Application No: EP/37/21/HH
Site Address: 2 South View East Preston BN16 1PX
Description of works: Replacement of cladding to gables and upper wall sections.

Thank you for your internet representation made on 20th May 2021 which has been recorded as an objection with the comments as follows:

I am commenting on behalf of the East Preston and Kingston Preservation Society.

Drawing:
Plans and elevations as proposed

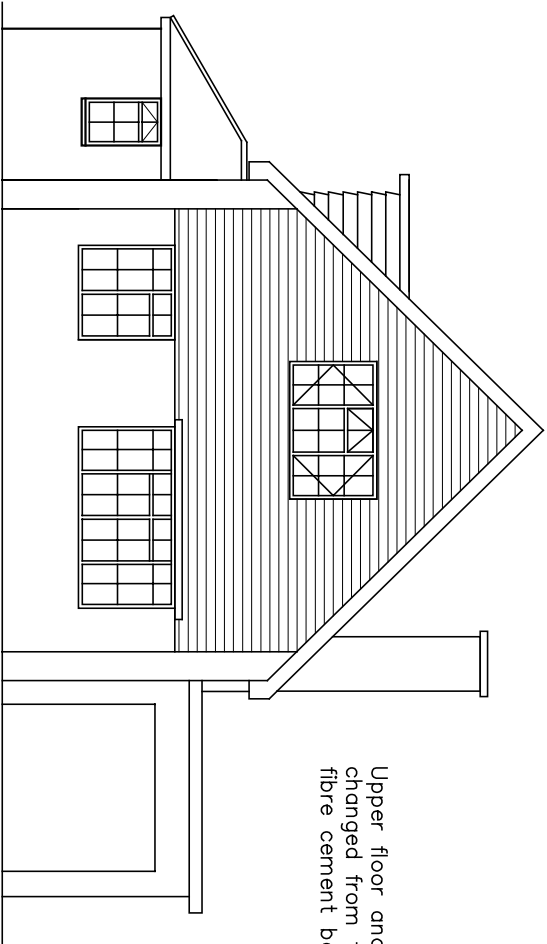
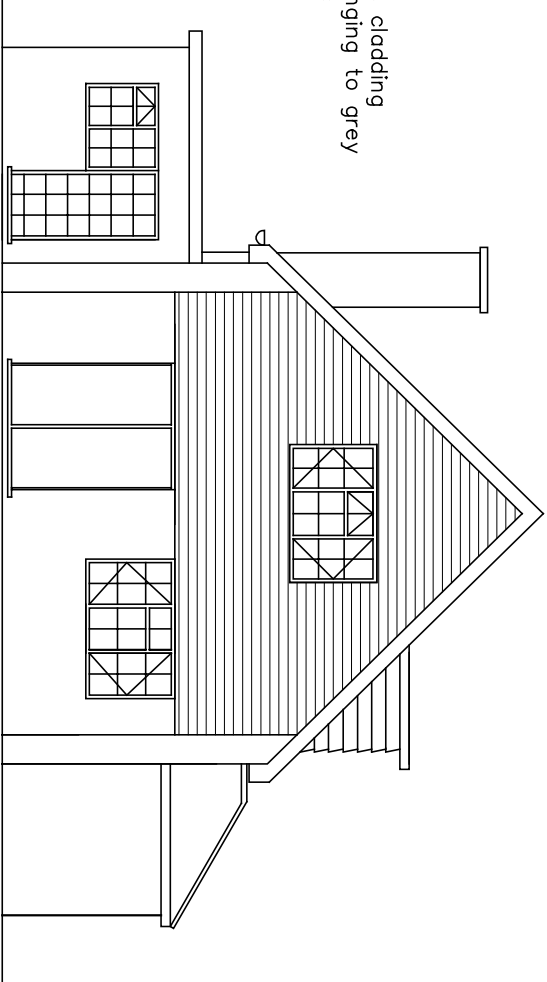
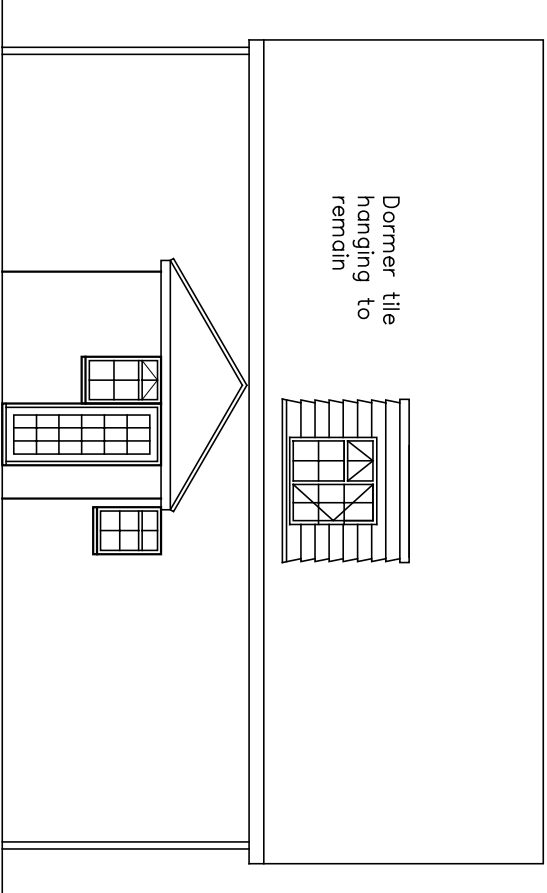
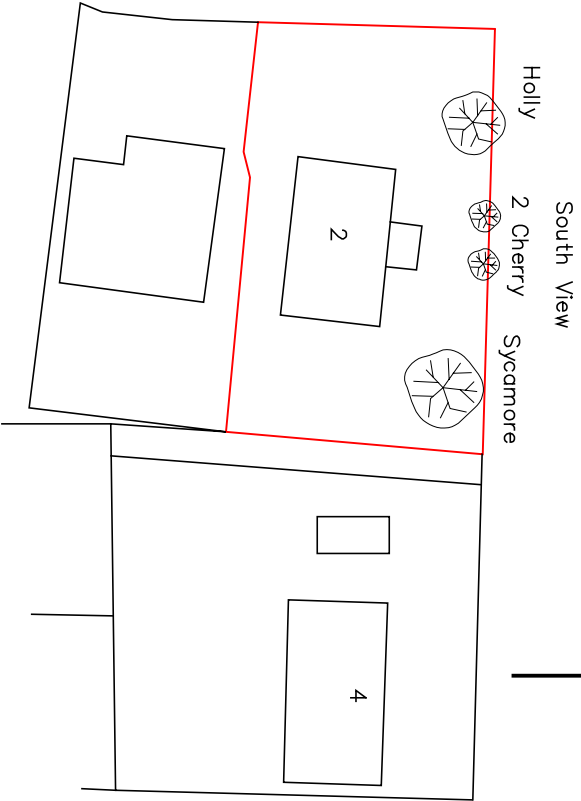
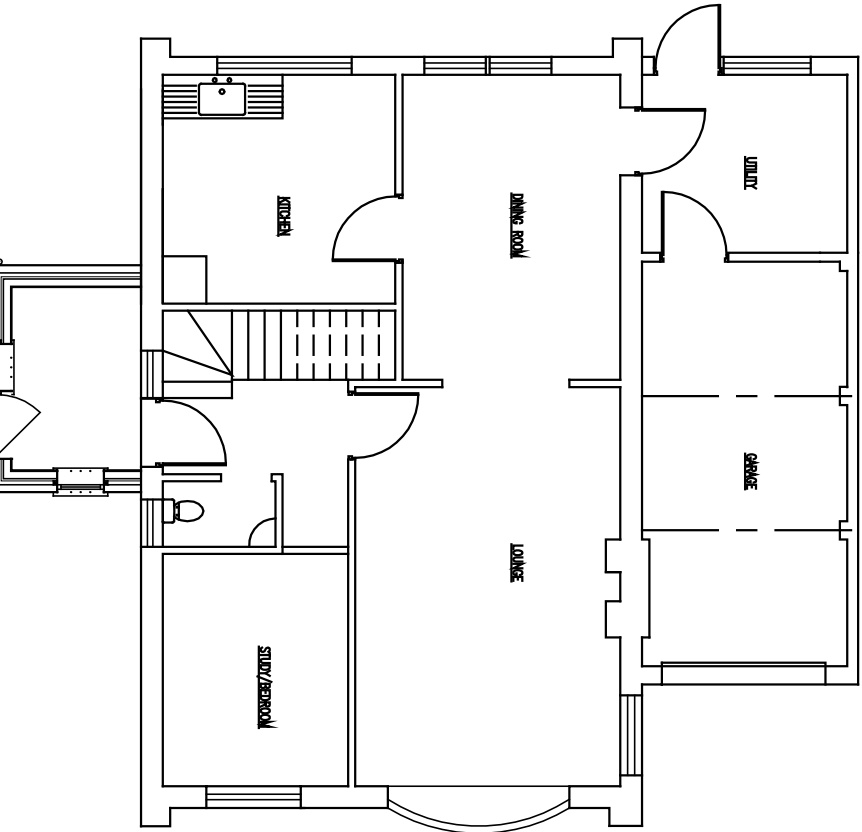
This proposal, to replace tiles with fibre cement panels on the upper half of the facade, would transform the appearance of the house. The result would be a building that was alien to its surroundings. There is one house round the corner in Homelands Avenue that has been faced with fibre cement boards, but it is out of sight from 2 Southview, and no houses in Southview are faced with this material. And one house does not change the character of the materials used in an area.

This application contravenes Policy D DM1 of the Arun Local Plan, because the proposed materials do not reflect the colour and texture of the materials used in the area; and it contravenes Policy 1 of the East Preston Neighbourhood Plan, because the proposed materials do not reflect the architectural and historic character of the surrounding buildings.
